**200 Codd's Road (Block 21) | Informal Pre-Consultation Review | T Bonhomme Architect, Wateridge Lifestyles Ltd. |**

**Panel Members in Attendance:** James Parakh | Heather Rolleston | Emmanuelle van Ruten | Colin Berman | Nigel Tai | Philip Evans |

PHASE 1 - LANDSCAPE SITE PLAN & CANOPY	
Date	2025-11-04
Scale	1:300
Drawn	JE
Checked	MK
Job No.	25-360
Sheet	L1.0

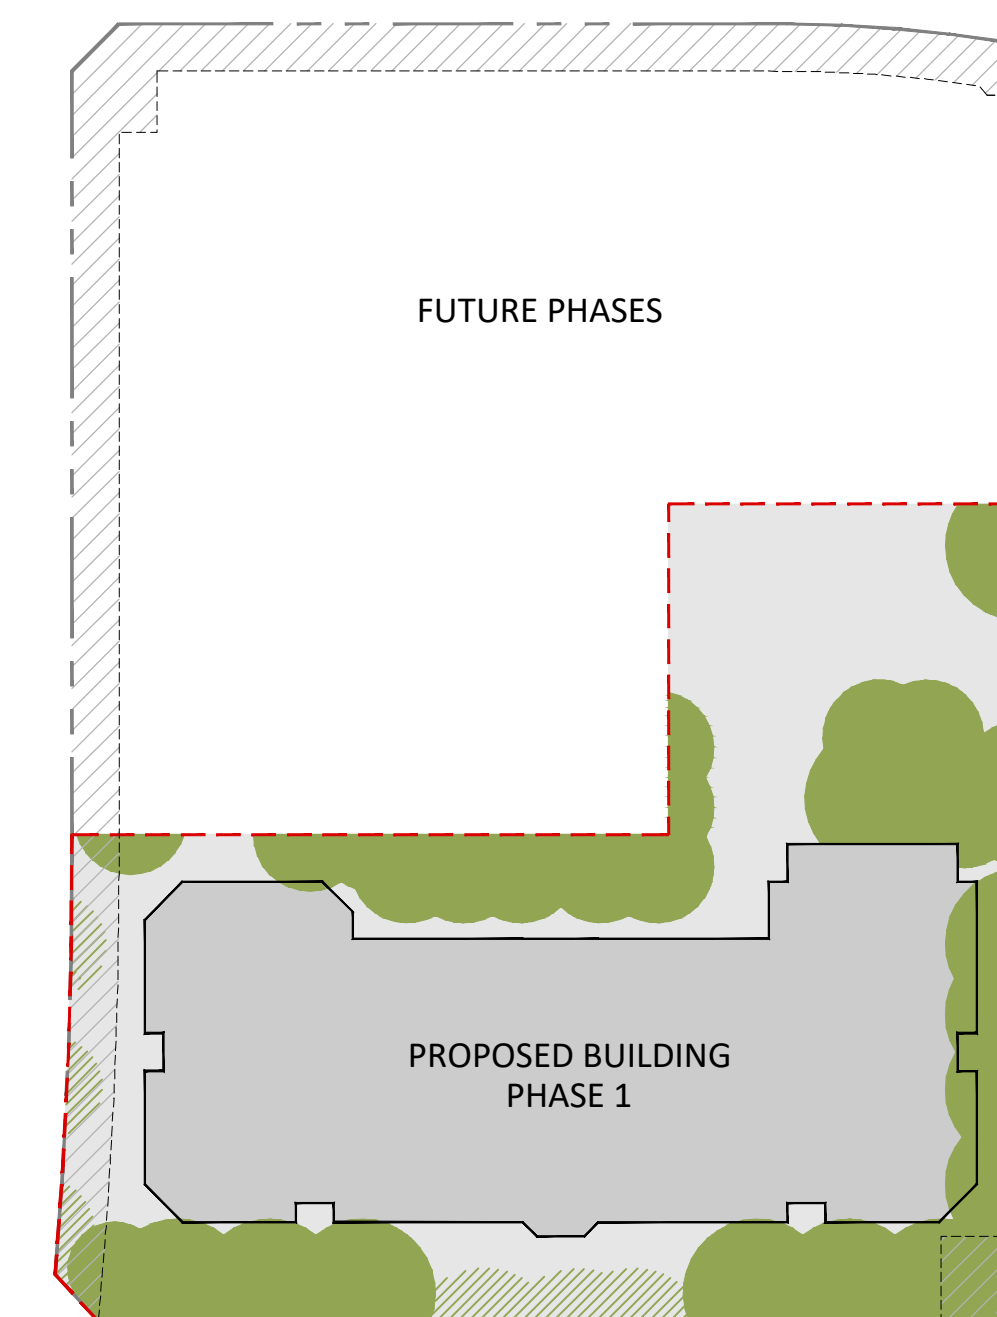
- The Panel suggests Phase 1 ramp can be relocated or configured differently, potentially toward the east, or whether a more direct entry into the building could be achieved, while maintaining visibility and safety for ground-floor residential units.

- The Panel notes that in Phase 1 the pedestrian pathway connection across the site is difficult to read and appears to be lost, and emphasizes the importance of establishing a clear, legible path through the site.

- The Panel notes that vestibules, parking ramps, and service elements are acting as physical and visual blockers where through-block porosity could be achieved, representing a lost opportunity to strengthen connections to the park.

- The Panel encourages further study of relocating bike parking and the small terrace to better consolidate or conceal these elements through enclosure, reduce congestion and allow greater flexibility in resolving service.

# CONCEPT PLAN - PHASE 1 & 2 SHARED AMENITY SPACE

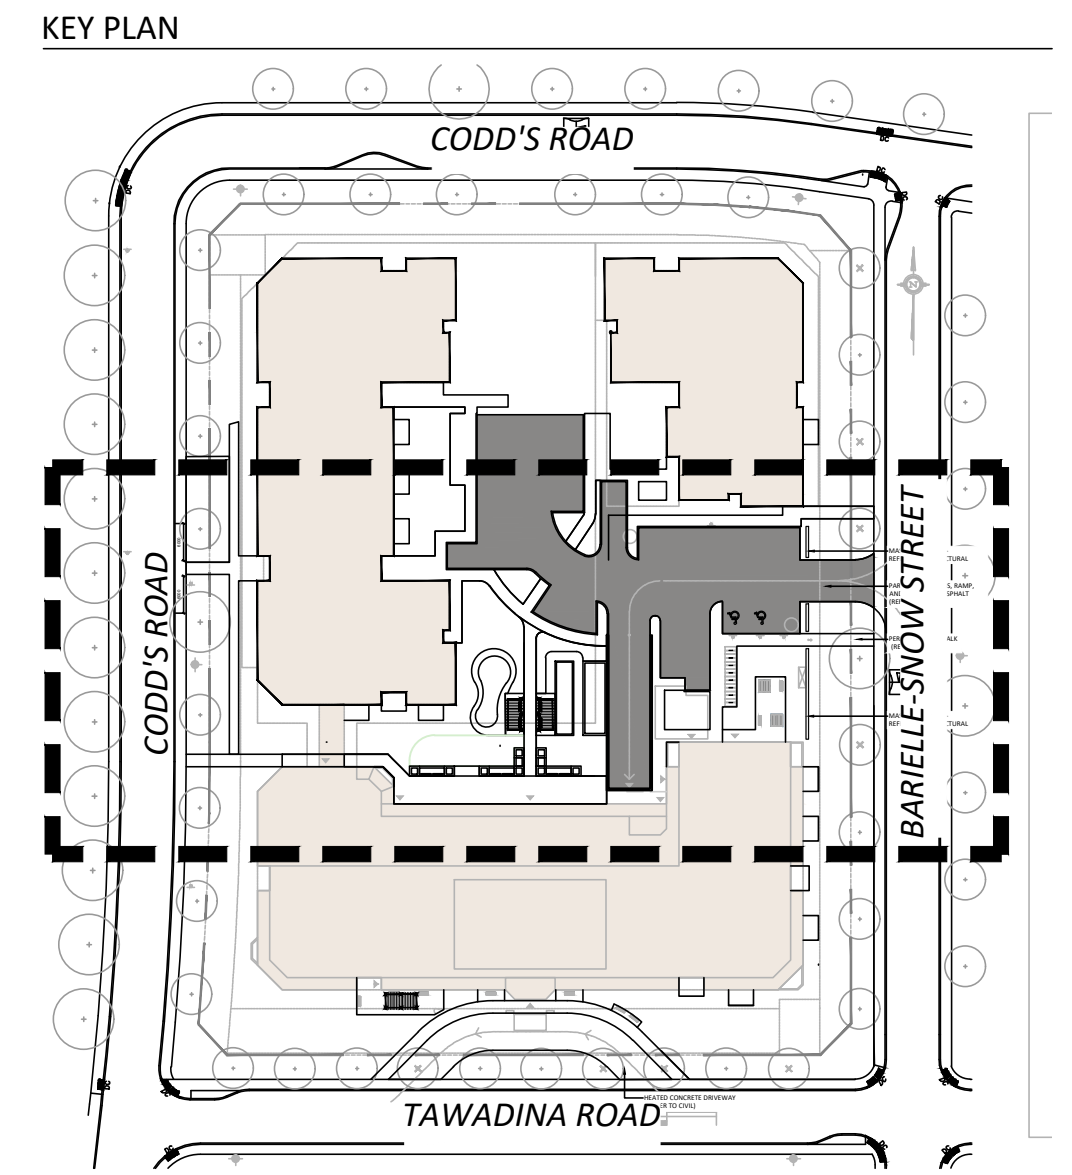
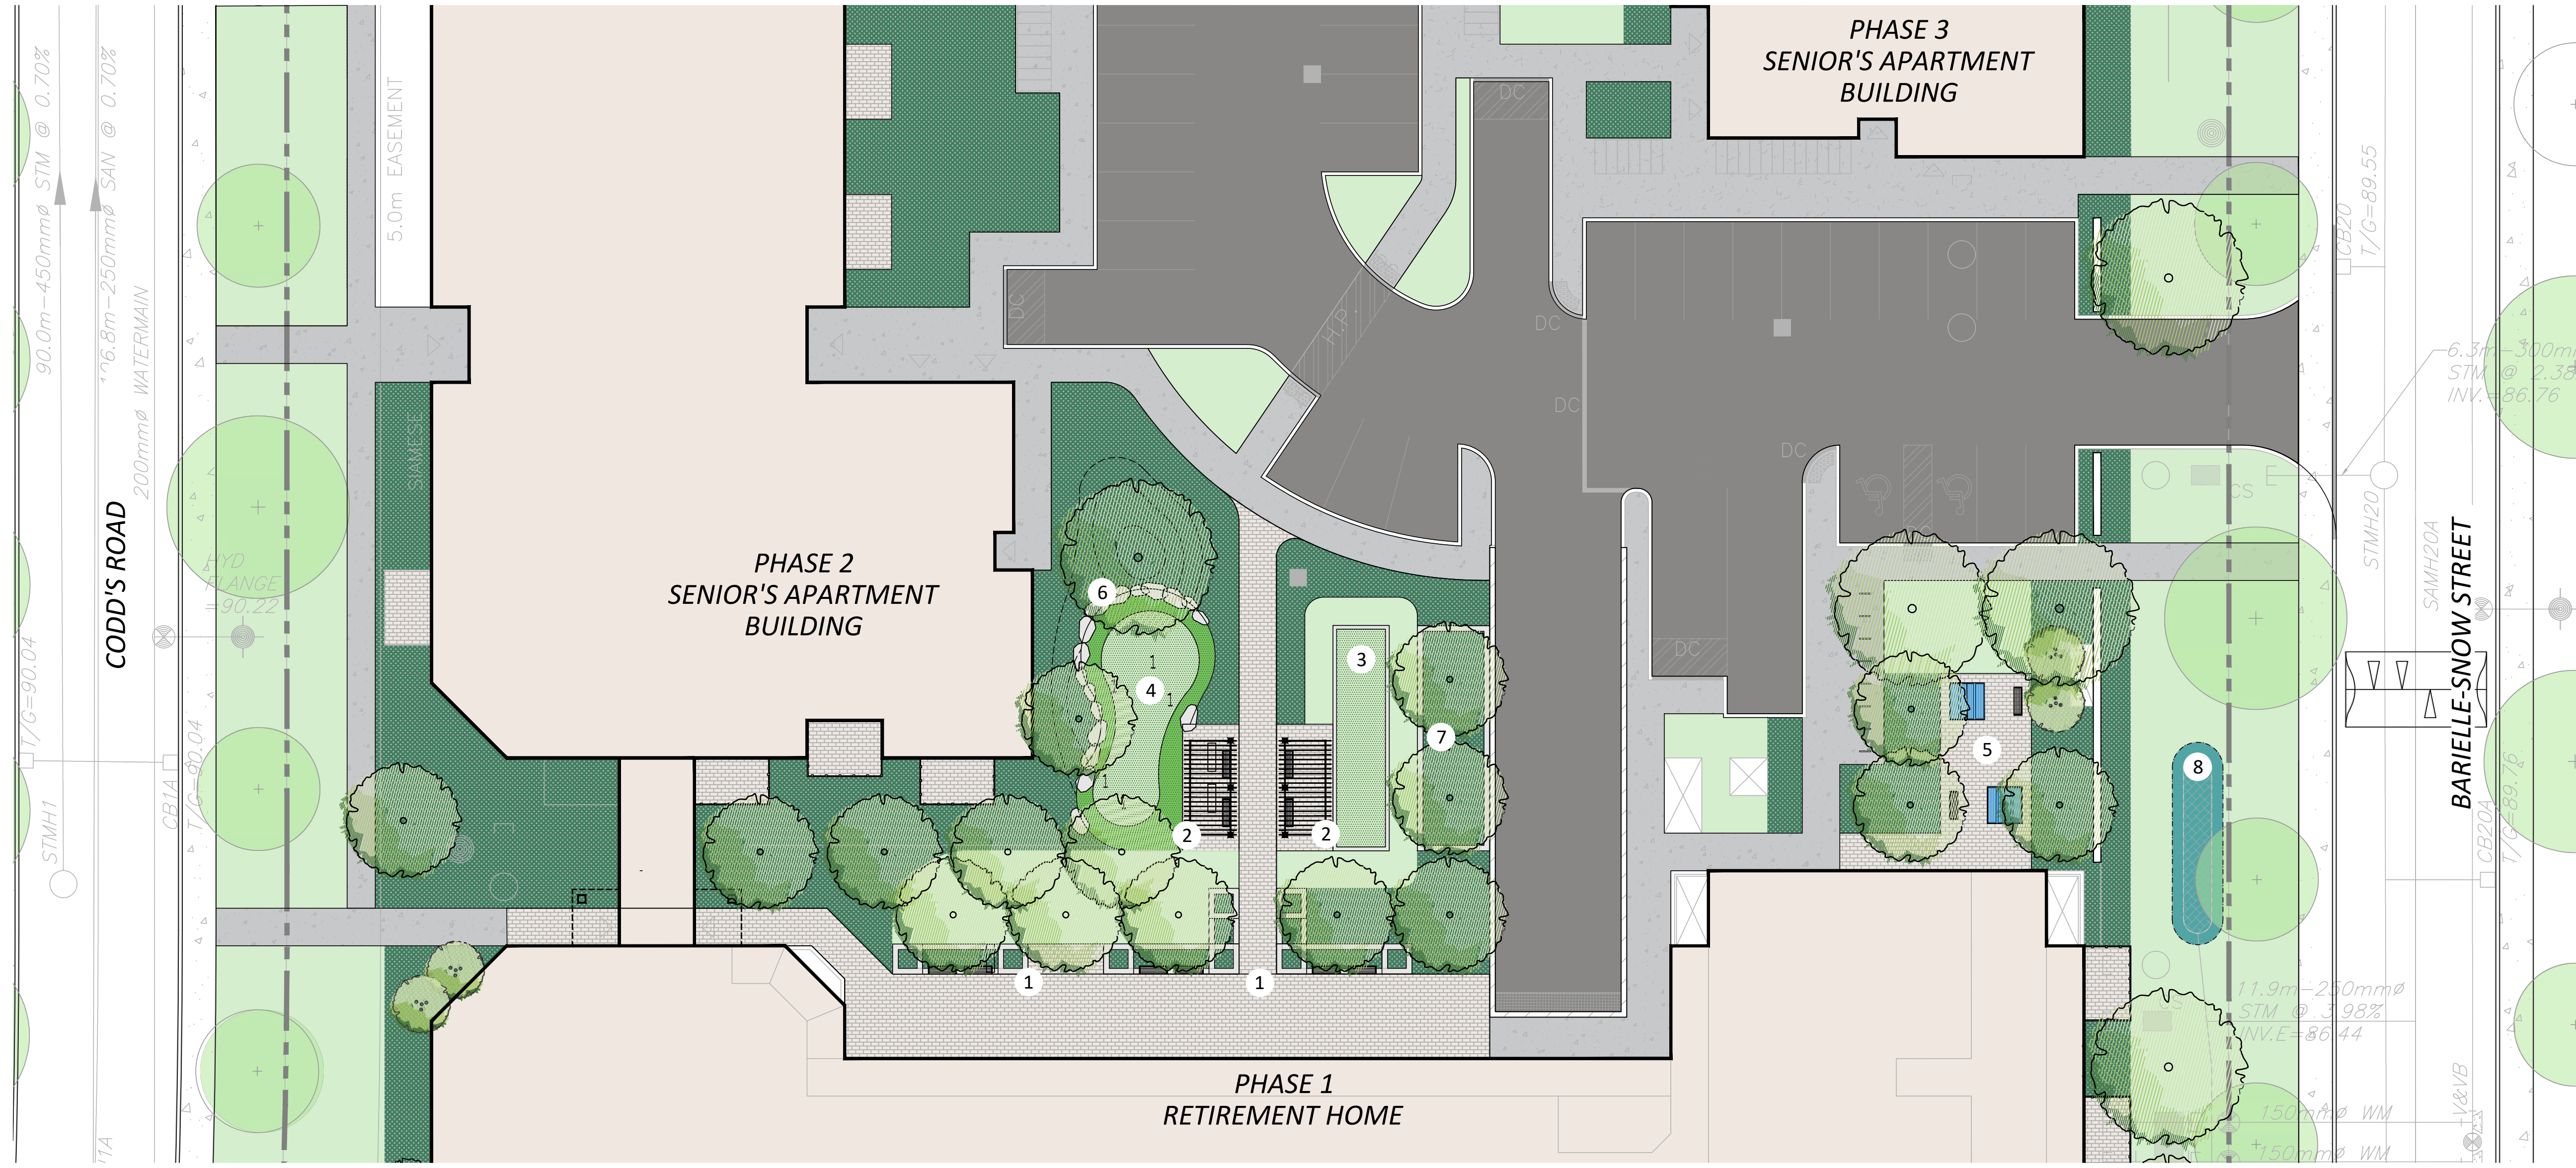
- The Panel recommends shaping the buildings more deliberately around this space to create a cohesive, usable, and holistic outdoor environment, rather than a negative leftover condition.

- Suggestions include flipping or reorienting building legs to open up a larger, more successfully shared amenity area.
- The Panel expresses concern regarding the generator, loading, and transformer area, which currently forms a prominent edge.

**DRAWING LIST**  
SOUTH & EAST ELEVATIONS - PHASE 1

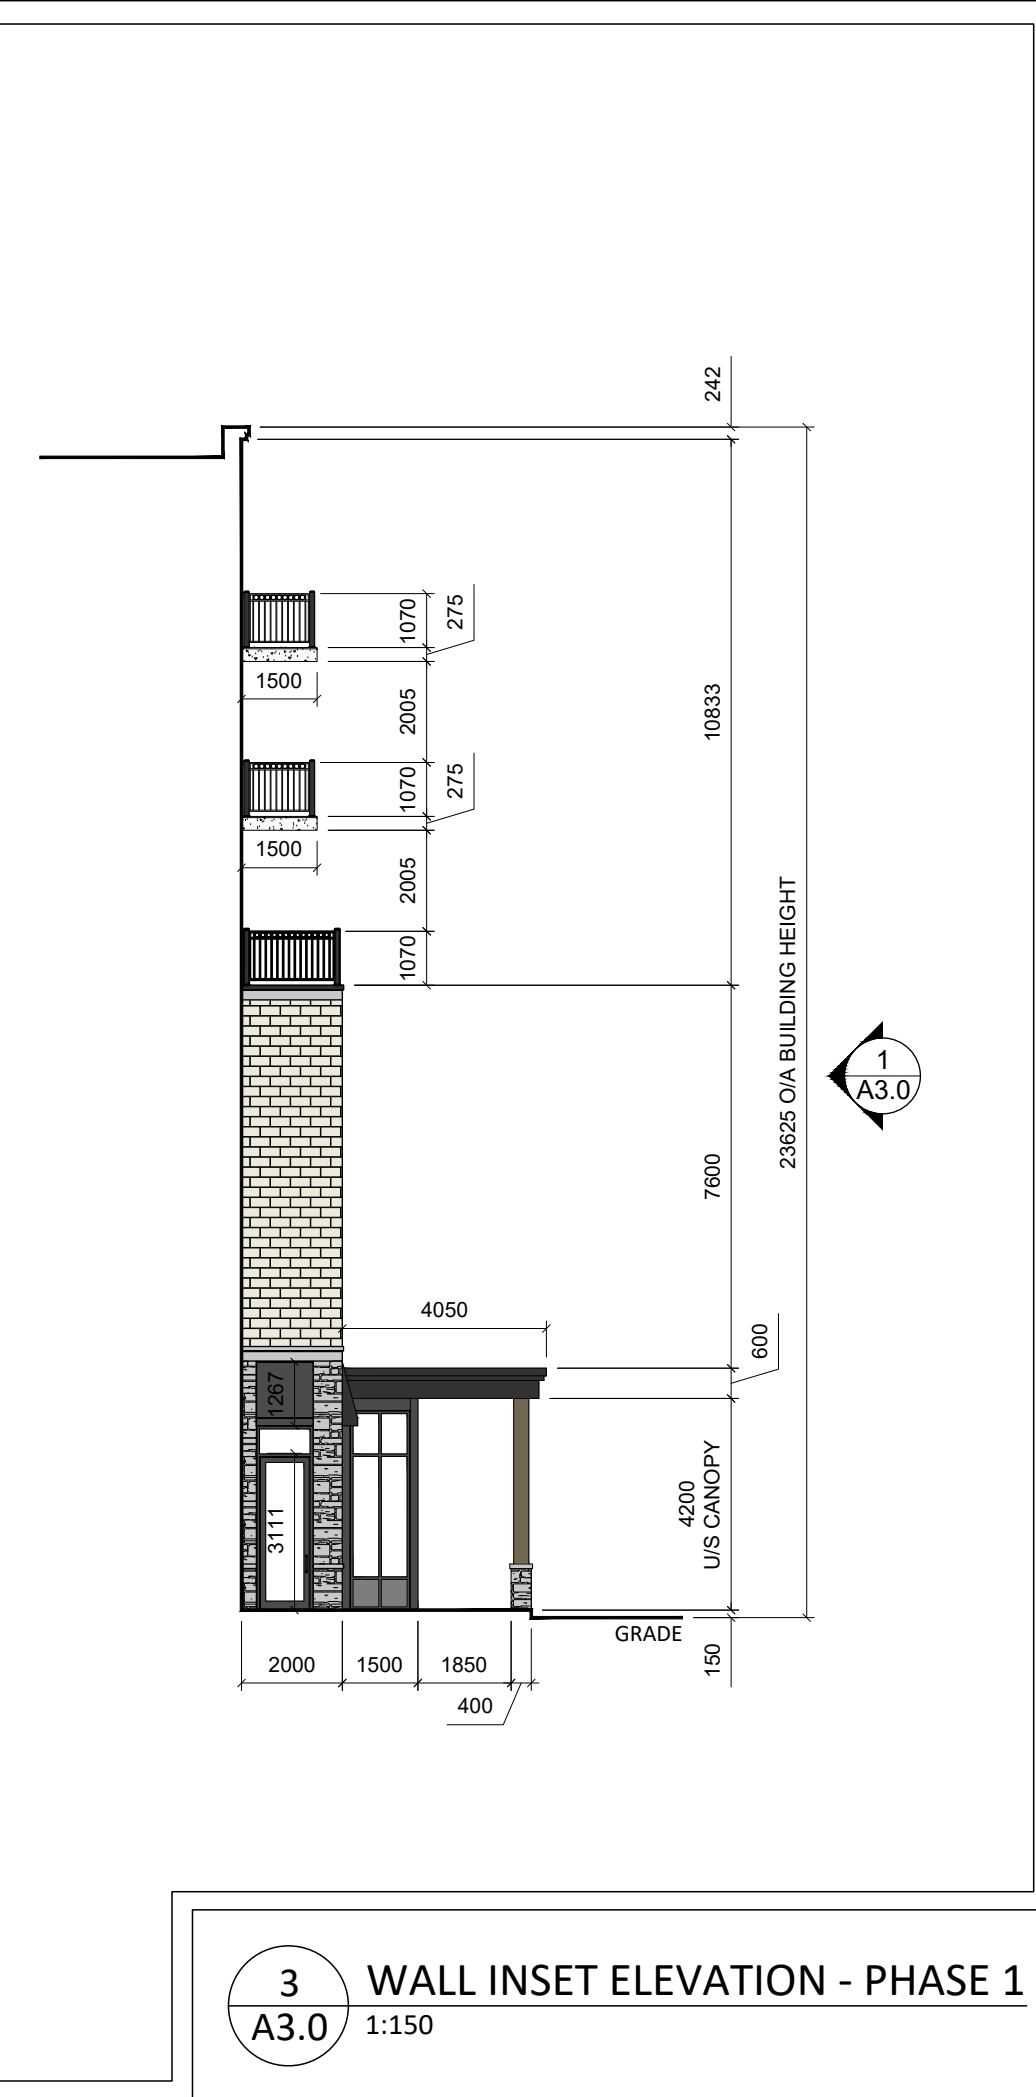
- The Panel expresses support for the use of rusticated stone at the base and encourages further refinement of proportions and detailing at the canopies. The current configuration leaves a very thin band of rusticated stone above the

canopy that feels visually awkward. Revisiting canopy depth, placement, and proportion could help strengthen the base expression.

- The Panel expresses concern about the proposed use of EIFS, citing issues of longevity and material performance.
- The Panel strongly encourages pursuing more durable, noble materials across the base, middle, and top of the building, even if this requires efficiencies or simplifications elsewhere in the building form.
- The Panel suggests further refinement in the floor plate size and configuration, including the potential for smaller floor plates or mirrored U-shaped buildings to better support the courtyard condition and improve amenity space.
- The Panel encourages the proponent team to look at successful Garden Court precedents and to find efficiencies in building form.
